Our Ref: R/77/19/L
Your Ref:

Application for Listed Building Consent for Alterations, Extension or Demolition of a Listed Building

Development Single storey rear extension
Location Mayfield Cottage 47 Sea Lane Rustington

DRAWING  
**LOCATION PLAN  
SITE PLAN**  
DRAWING No  
**285/01**  
SCALE  
DATE  
1:1250 1:500  
MARCH 2019  
REVISION  
**A**  
DRAWN  
CHECKED  
LA

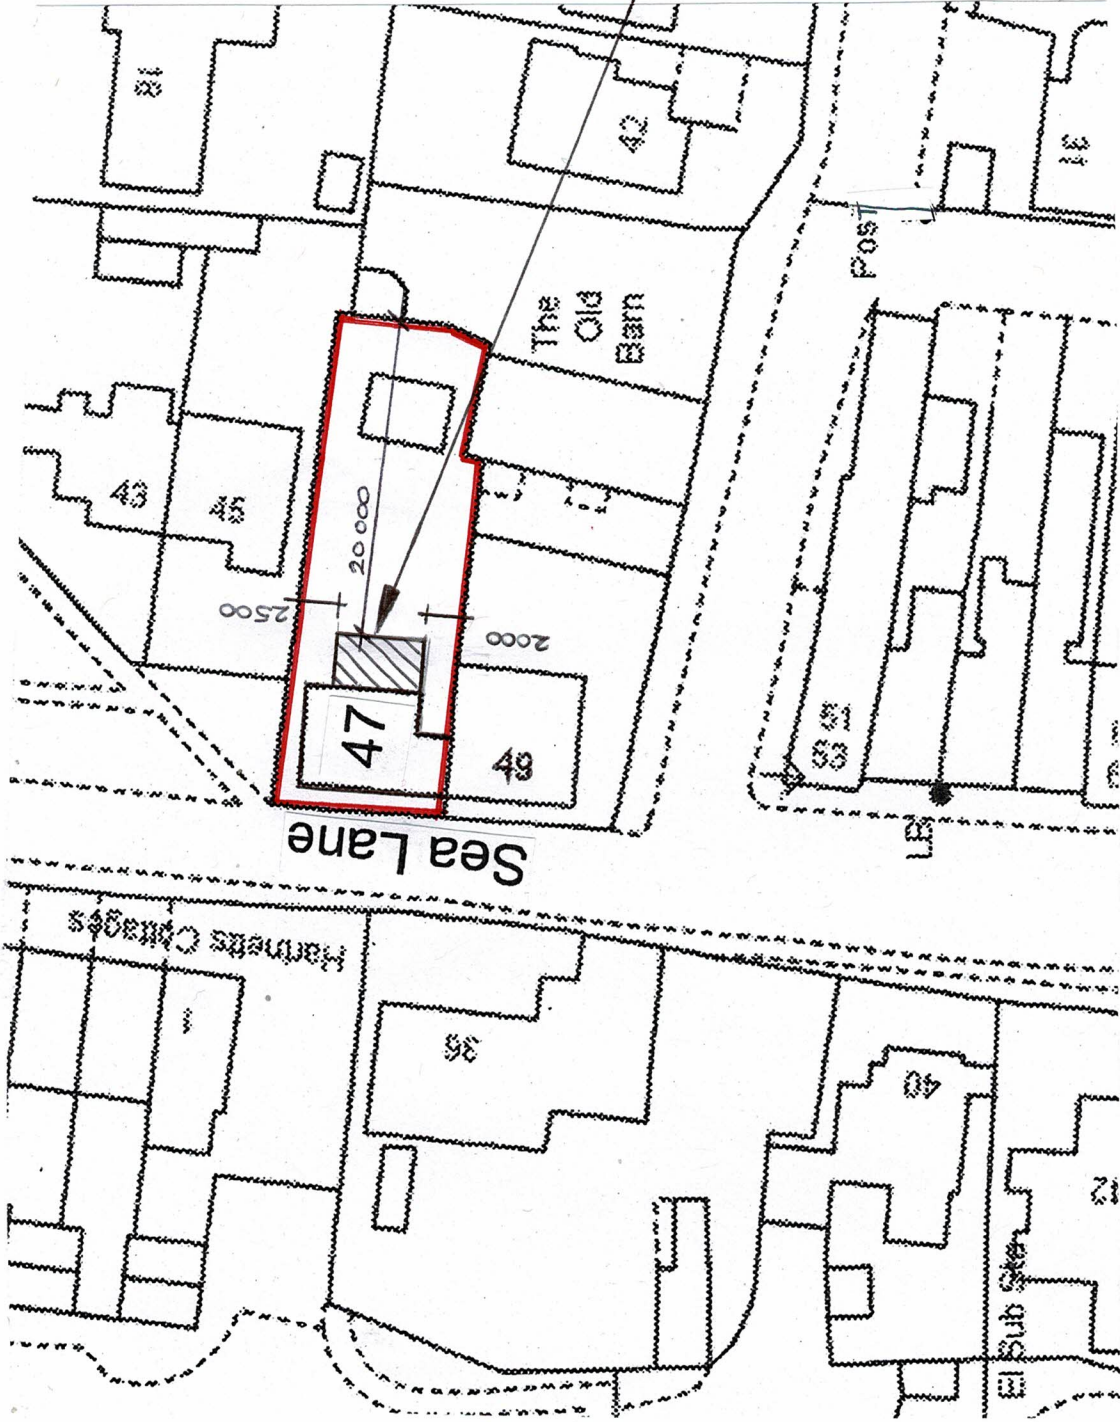
Block Plan

Please include a dimension to the rear boundary on your block plan.
